TOWN AND COUNTRY PLANNING ACT 1990

APPROVAL REQUIRED BY CONDITION OF PERMISSION

Reference: H08-1298-16 **Date of Decision:** 1st February 2017
Applicant: Mr P Twell
258 Siltside
Gosberton Risegate
Spalding
Lincs
PE11 4JR
Location: 258 Siltside Gosberton Risegate Spalding
Description: Large scale details (Condition 9 of H08-0803-09)

Drawing
EXISTING SURROUND DETAILS
PROPOSED SURROUND DETAILS

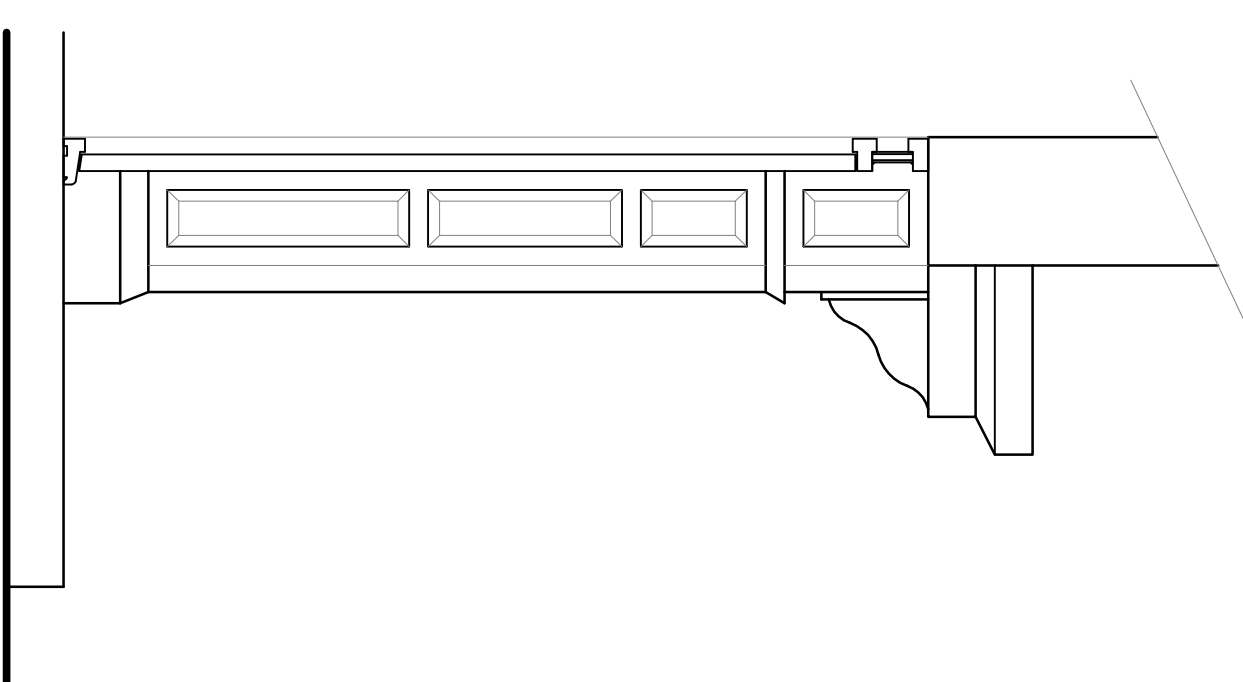
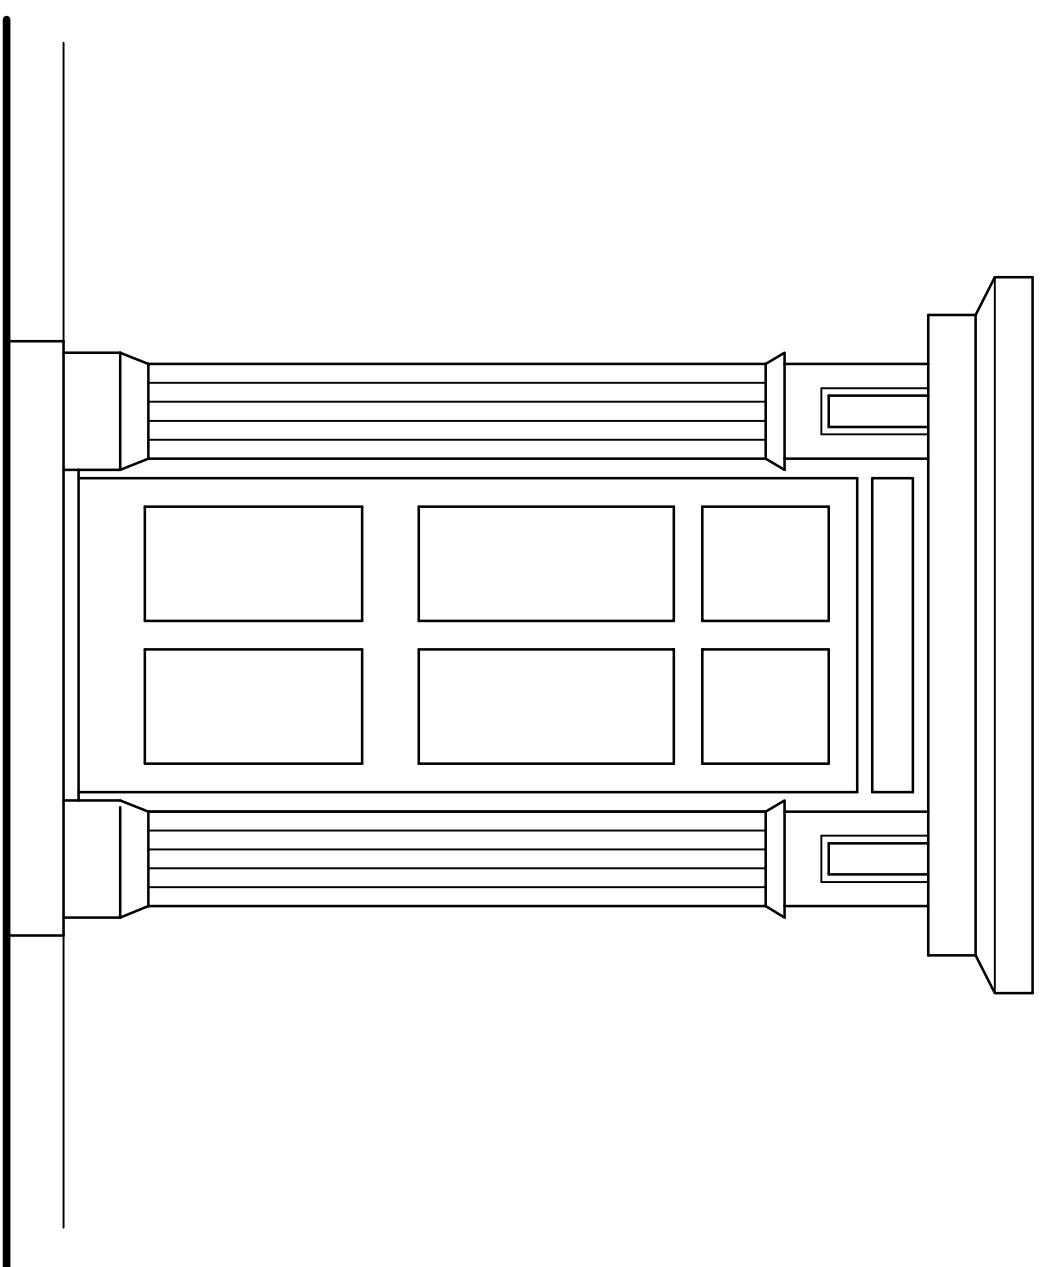
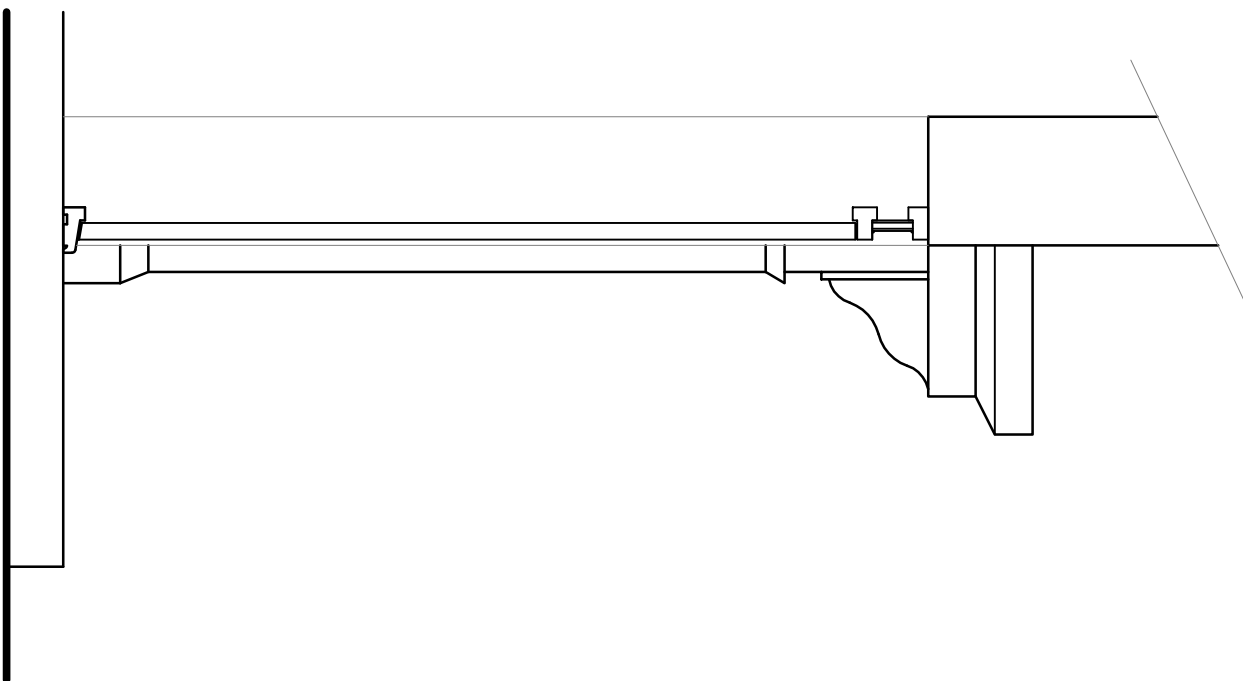
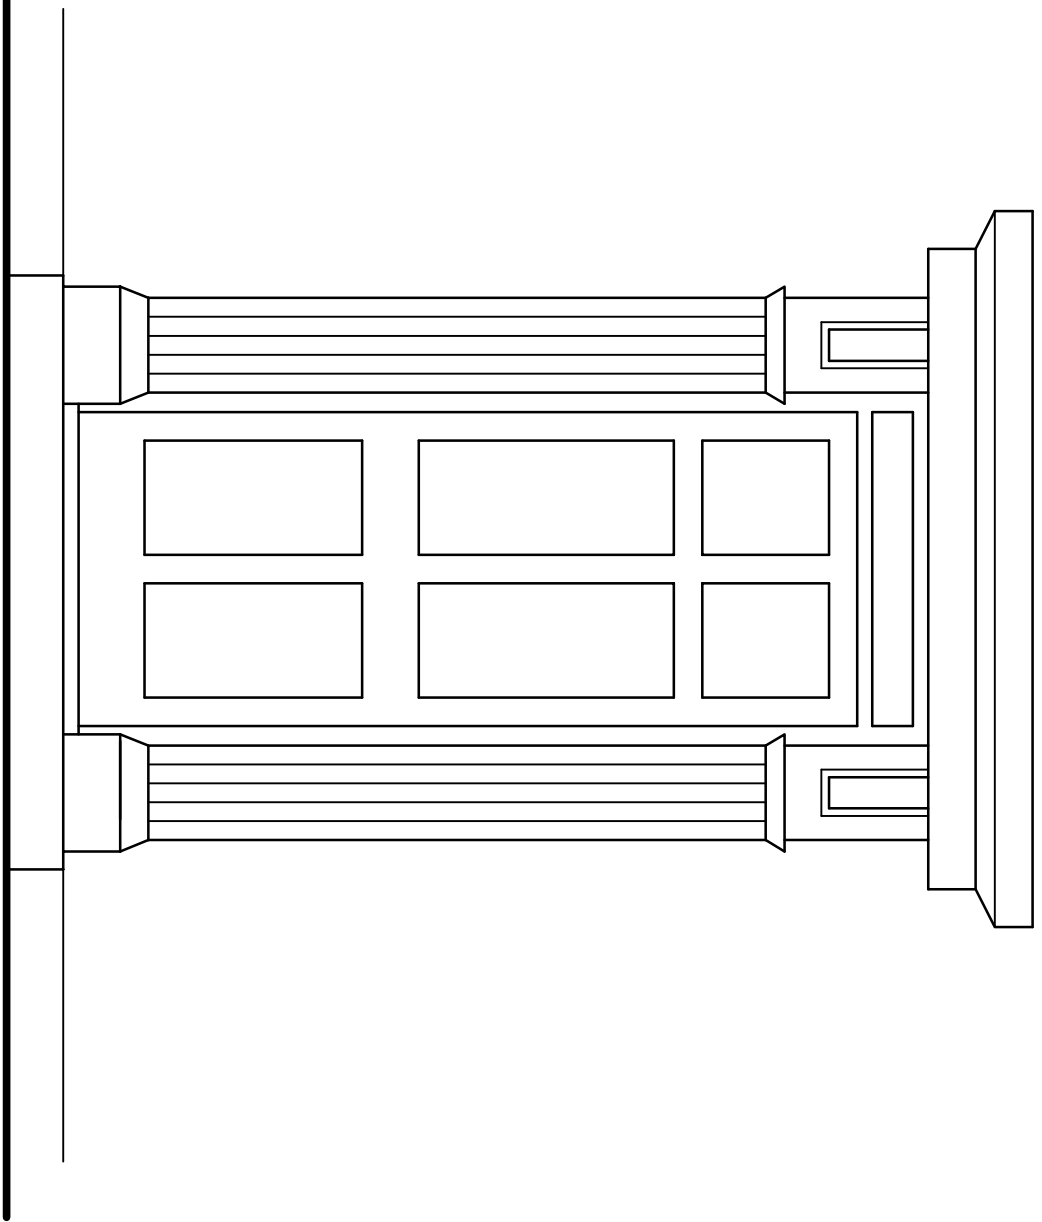
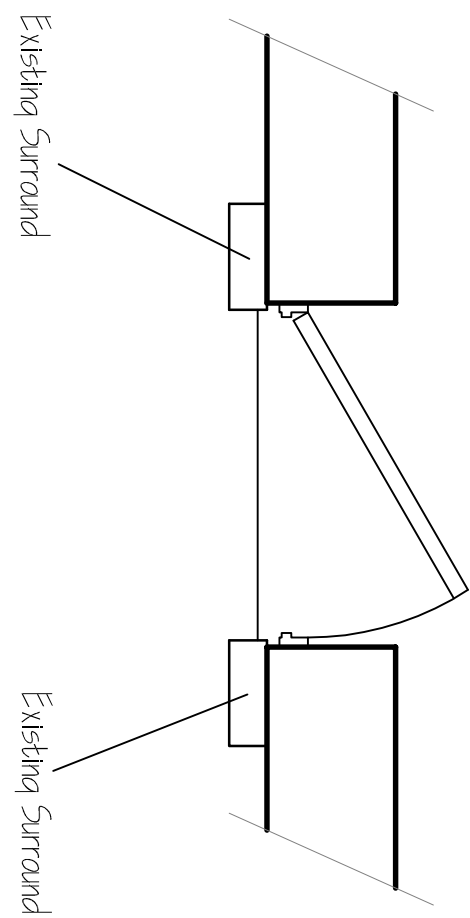
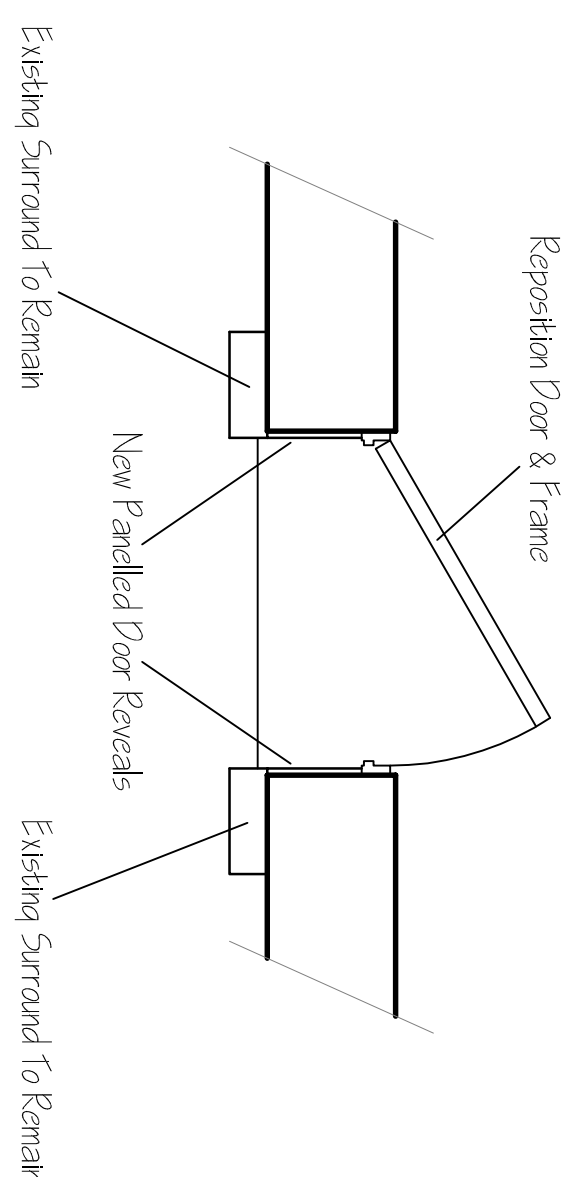
- 1 The retention of the front door canopy, surround and overlight as constructed, in conjunction with the proposed door reveal, are considered to be unacceptable in terms of the quality of their design detailing, materials, method of construction and their relationship to the well-measured Georgian architectural character of the host-building. In particular, whilst the front door surround, canopy and reveal are a crude approximation of the traditional, classically proportioned joinery common to houses of this period and status, the door surround is not integrated into the brick work as it should be, but is attached on top of the existing brick as a separate addition. The existing door surround has bland detailing, and is already showing signs of deterioration and poor construction. Given that this replacement dwelling greatly exceeded the normal policy limitation of a 20% increase in total floor area, and as such was only justified on the basis that it would deliver a high quality of architectural design and detailing, it is considered essential that the high standard achieved by the remainder of the development is not watered down by prominent architectural features of substandard design. The existing front door surround lacks the detailing and status expected for a main entrance of this size of dwelling in relation to Georgian proportioning, and would consequentially have an adverse effect on

the character and appearance of the surrounding area. Therefore, the details as submitted are contrary to the provisions of Policies SG14 and HS17 of the South Holland Local Plan, 2006.
